COLORADO GEOLOGICAL SURVEY

December 22, 2017

Subject: Crystal Park Site 315R – 4854 Crystal Park, El Paso County, CO,
El Paso County File Number CP-17-10, CO; CGS Unique No. EP-18-0025

A Site Plan
SP1 SCALE: 1" = 20'-0"

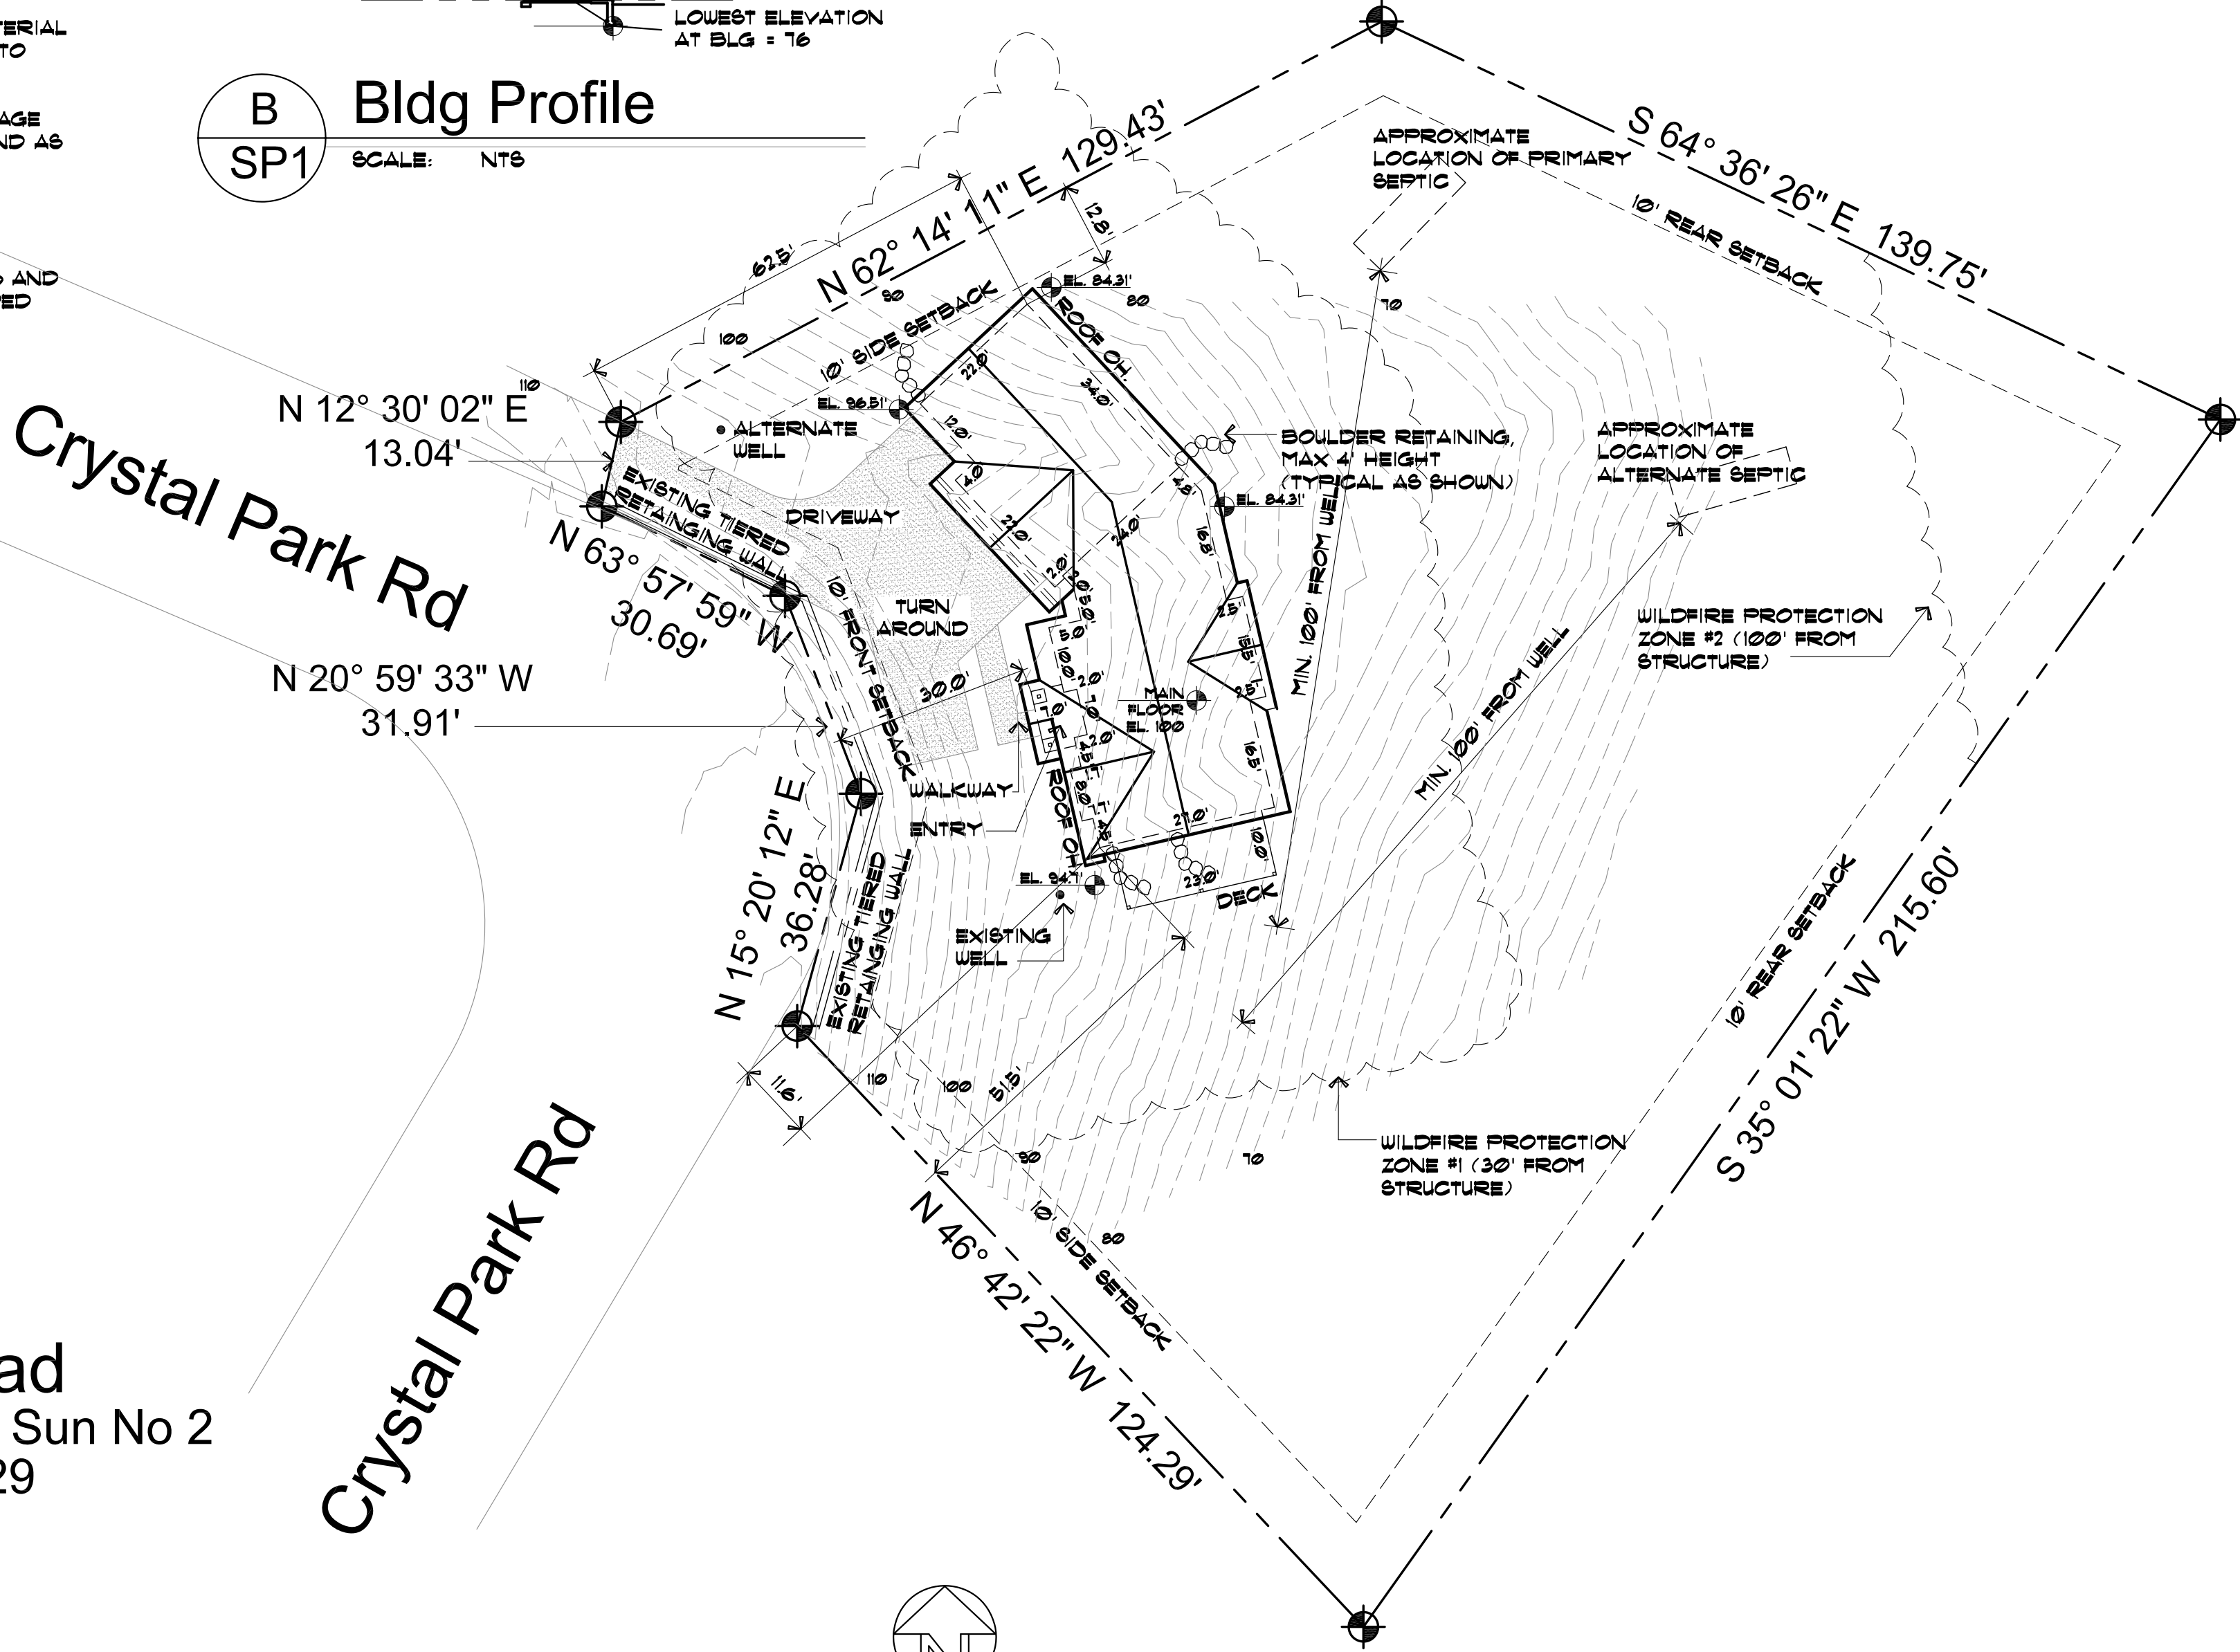
Steep slopes. The lot contains steep slopes, and the site plan shows the structure in locations with slopes estimated to be greater than 45%. While mapped landslides are not present and evidence of existing slope instability was not observed there are risks associated with construction on these steep slopes where erosion is also a significant constraint.

- Slopes that appear to be currently stable can be destabilized if modifications are made through excavation of cuts, addition of fills, and loading due to structures.
- Presently stable slopes may become unstable, as a result of reduced soil strengths, if 1) significant moisture is added to the slope through residential irrigation (including infiltration from septic fields), extended precipitation or snowmelt, and/or 2) the existing drainage pattern is altered through grading, introducing water to areas that were previously drier.
- Block slope failures in the bedrock can occur along concealed fractures and weathered zones anywhere beneath the planned building site. The foundation excavation should be carefully inspected for evidence of fractures, discontinuities, and weathered zones.

Surface Drainage and Erosion. The onsite soil and colluvium (“Grus”) is highly susceptible to erosion. Concentrated, developed flows can cause serious and damaging erosion and rapidly erode the surface material down to hard rock. Site drainage should be designed and constructed to prevent concentrated flows from being developed within the site. Drainage should be designed to prevent any flows from Crystal Park road being directed at the lot.
